**Consultation Response from KC,  
Ecology Unit**

**2023/93237 Brayside, 71, Coach Road, Cowcliffe, Huddersfield, HD2 2NW**

**Demolition of existing dwelling and garage and erection of detached dwelling with detached garage**

**Date Responded: 30/01/2024**

Drawing Title
Planning Drawing

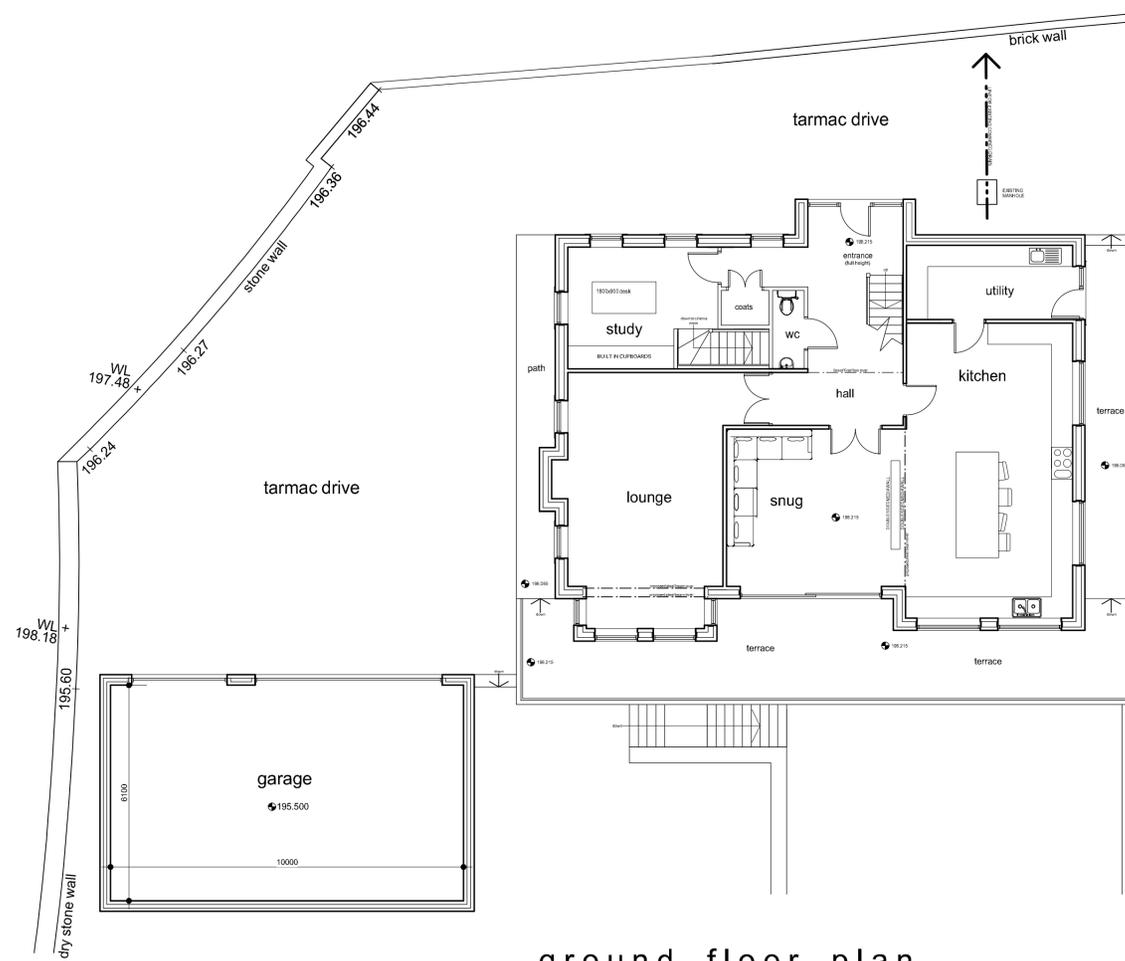
Given the above, the proposals should look to relocate the proposed garage at the site, as at this stage, it seems as though the proposals lie within 15m of the boundary of the woodland.
